Cambridge Waste Water Treatment Plant Relocation Project
Anglian Water Services Limited

Book of Figures – Traffic & Transport

Application Document Reference: 5.3.19
PINS Project Reference: WW010003
APFP Regulation No. 5(2)a

Revision No. 04
April 2024

Figure 19.2

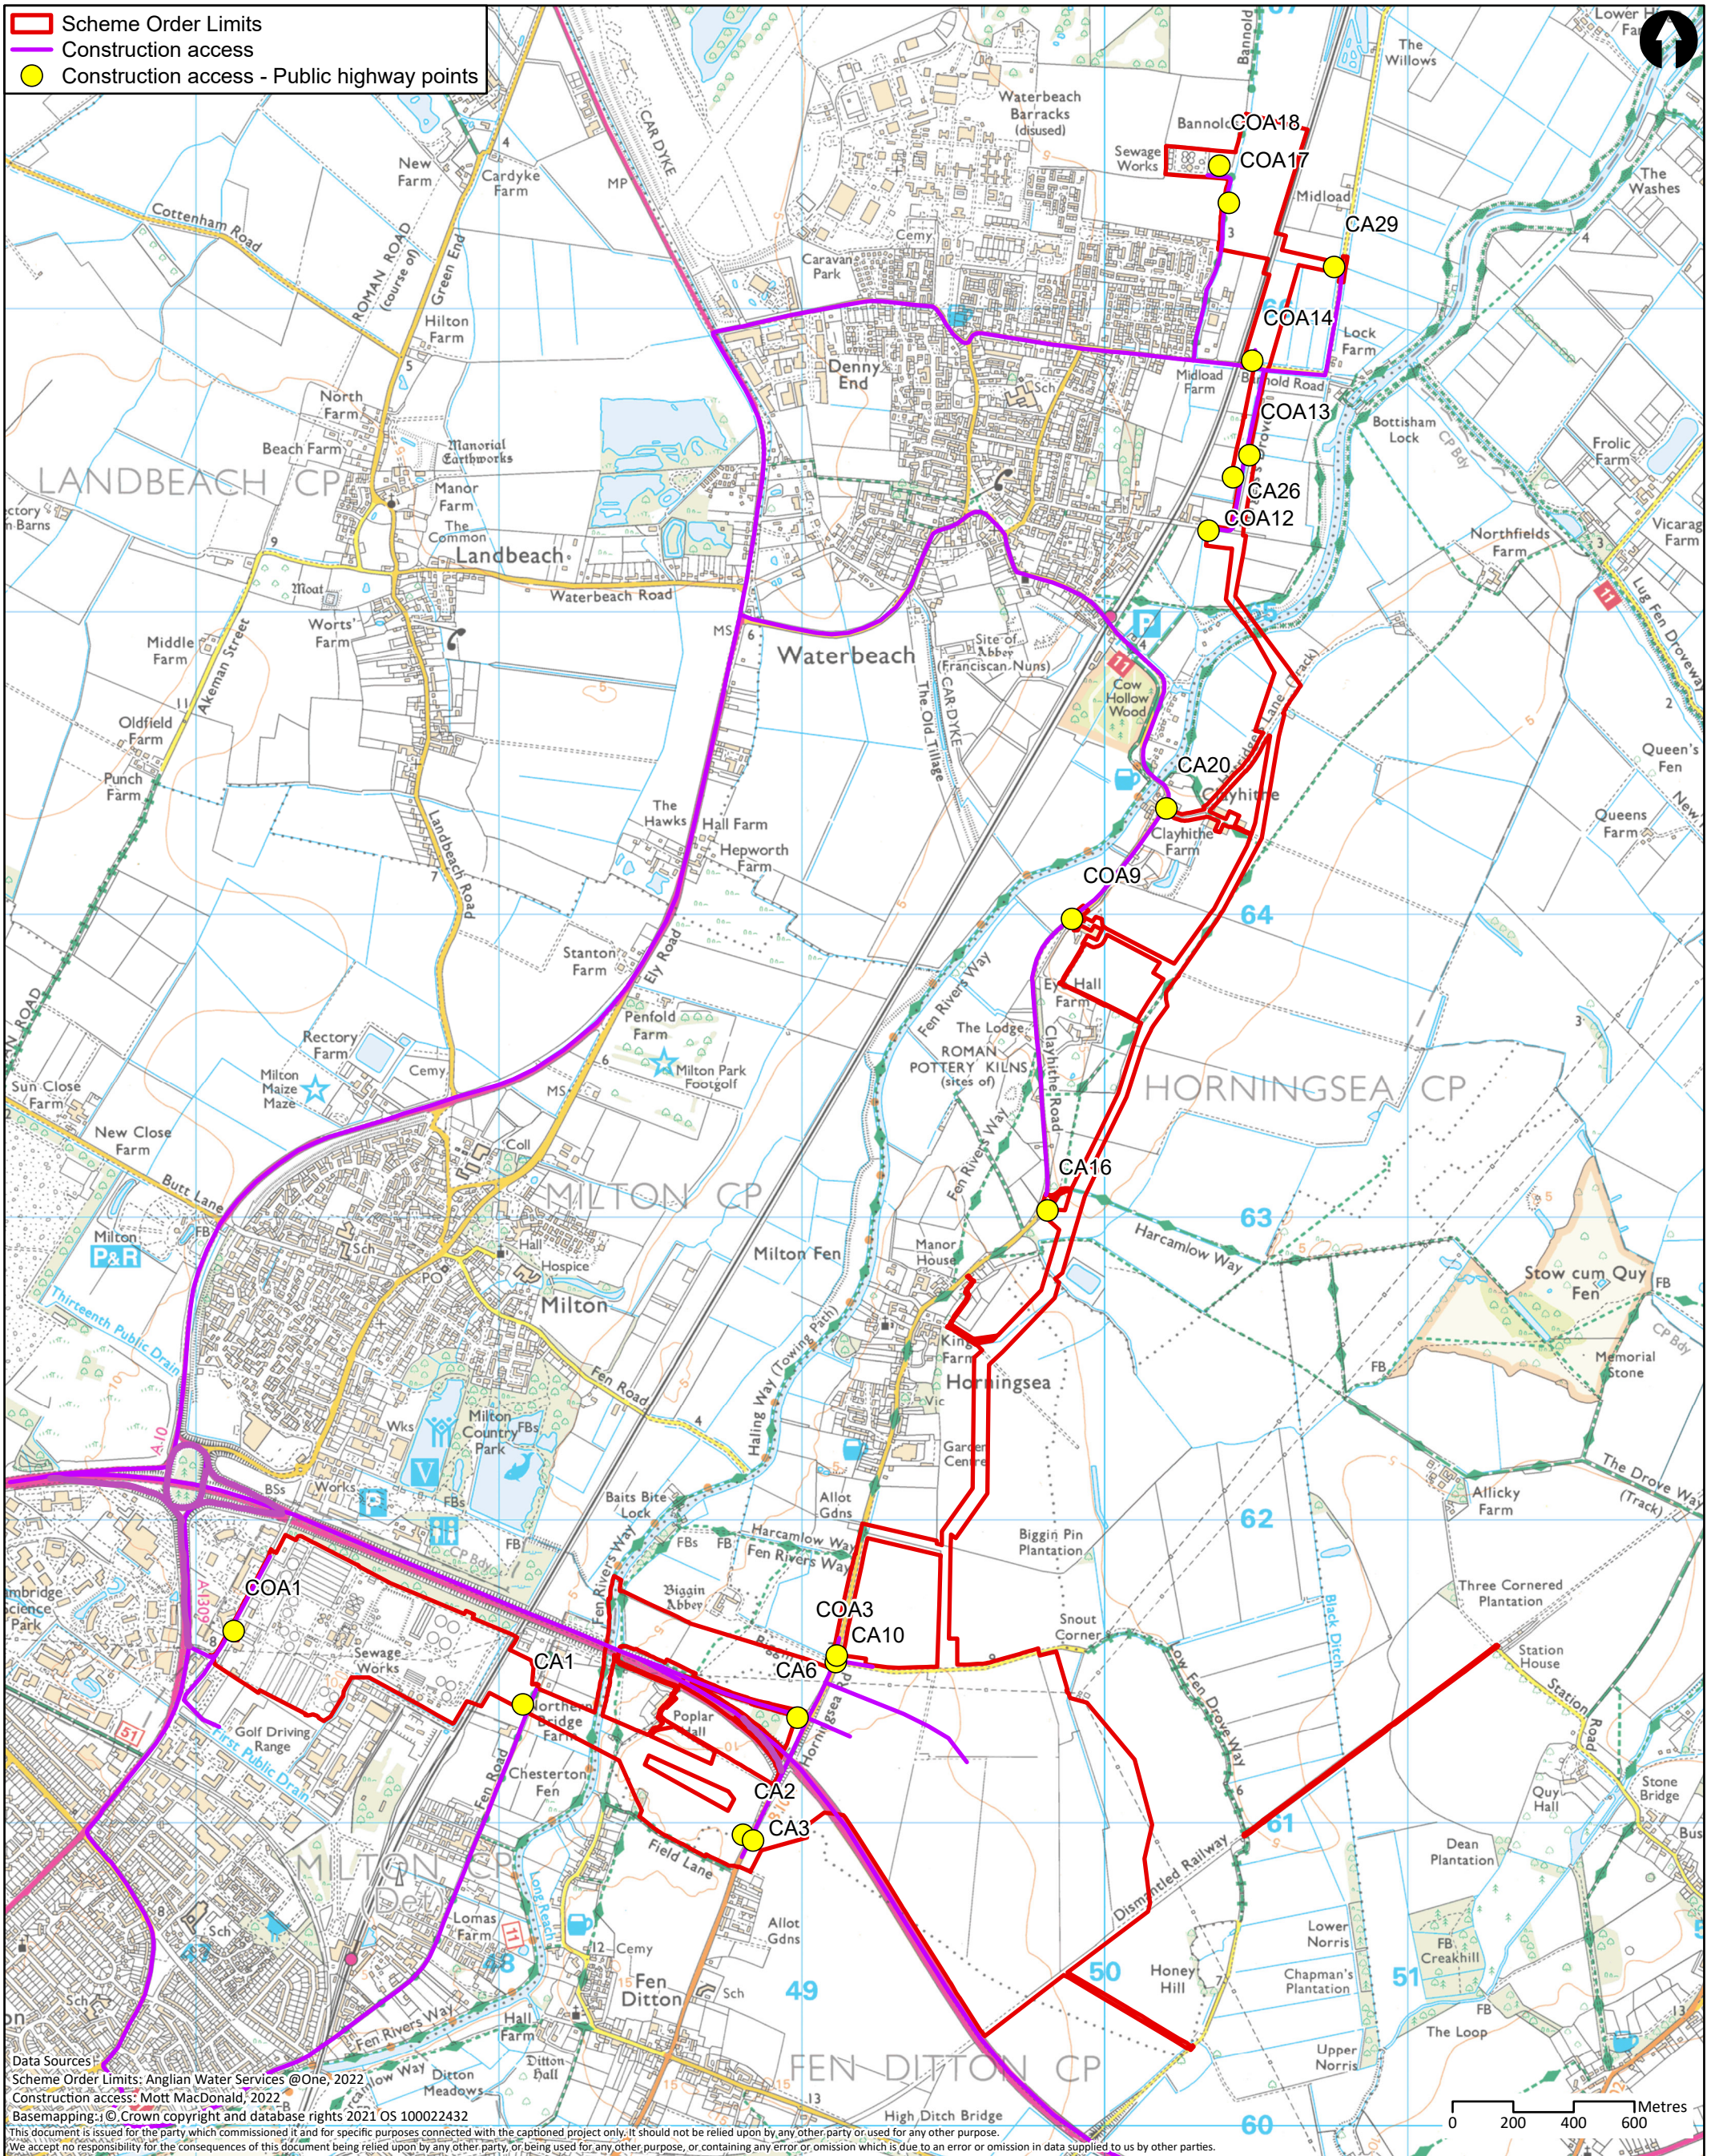
- Figure 19.2 was updated by the Applicant to clarify that the construction traffic access (COA12) for the Waterbeach Pipeline is into the field prior to the entrance to the allotments and does not extend to the railway crossing on Burgess's Drove.

- The Applicant has added an inset box to Figure 19.2 to show the area around COA12 in more detail.
- Figure 19.2 has been updated by the Applicant to reflect changes requested in ISH3, to show both construction routes (denoted by purple lines) and ALL routes (denoted by pale blue and green dashed lines) on the one plan.
